**From:** Sue Howell  
**Sent:** 20 April 2017 15:26  
**To:** Claire Potts  
**Cc:** Lucy Harding; Joe Russell-Wells  
**Subject:** RE: AL10716RES - revised plans (email 1)

Further to submission of revised plans Dwg No BDWS20440 11G sheets 1-4 re landscaping/Revision G additional planting to central pond, I can confirm that they do now contain sufficient information following our request for additional landscaping to the pond areas. We note also now the inclusion of the provision of 1.2m high post and rail fencing to pond surrounds as shown and discussed.

**From:** Wright, Aaron [REDACTED]  
**Sent:** 12 April 2017 16:47  
**To:** Claire Potts  
**Cc:** Lucy Harding  
**Subject:** AL10716RES - revised plans (email 1)

SPECIFICATION
All works generally, to comply with the written Soft Landscape Specification.

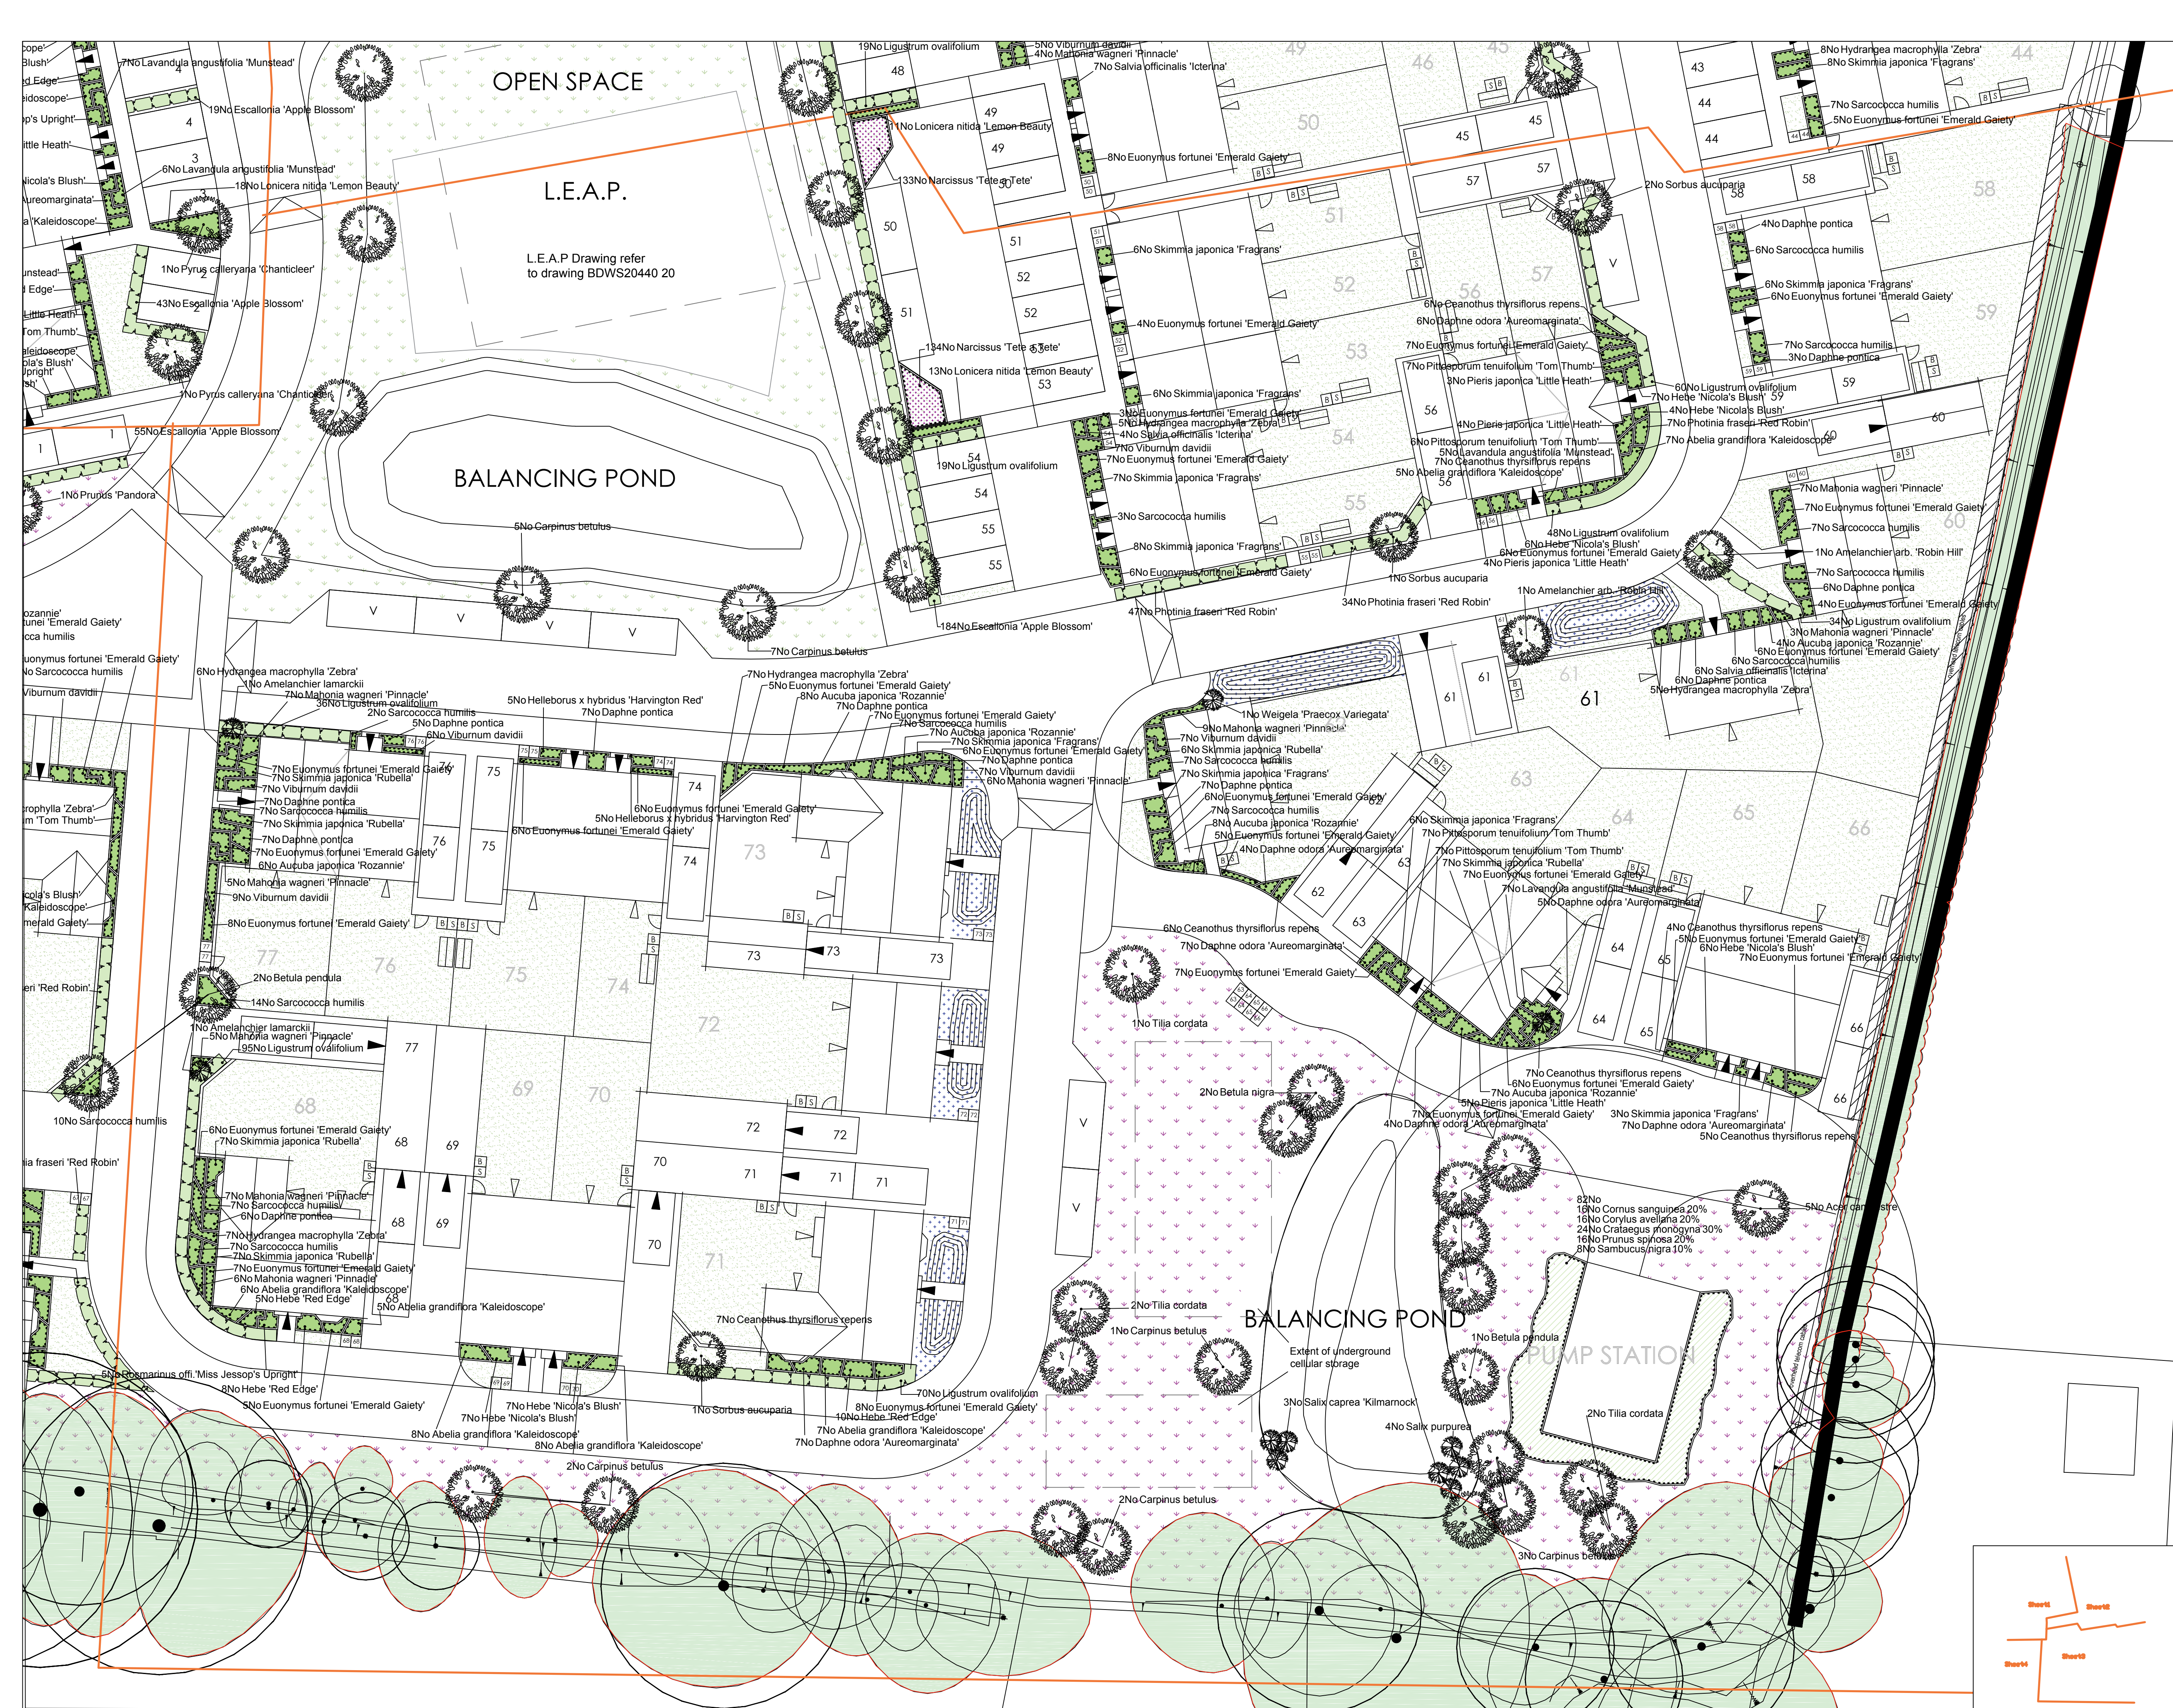
I have had a look at the attached revised plans, which the general landscape arrangement across the drawings is fine. We had however discussed some provision of planting to the periphery of the central balancing pond adjacent to the LEAP, which does not appear to feature on these plans?

There is now a very token of planting to the balancing pond adjacent to the pumping station (7no Salix) but nothing detailed to the central one? Which is where we would have liked to have seen the addition of some groupings of water tolerant planting. Not sure if this is an intended omission or if the developers were given this feedback or not?

In summary the general Landscaping scheme is fine, so too is the addition to provide a 1.2m post and rail fence to the pond edges, we would however recommend the addition of further planting be proposed to both of the balancing pond edges.

- 3m easement along the eastern boundary adjacent to the ditch, as requested.
- Landscaping drawings amended to reflect the comments of the landscape officer.

Lucy,  
Please find attached the revised landscape drawings. The plans show SUDS Wildflower Turf (WFT-SUD-37) as supplied by Wildflower Turf of similar and approved, within the balancing ponds. The ponds are shown to be enclosed by a 1.2m post and rail fence.
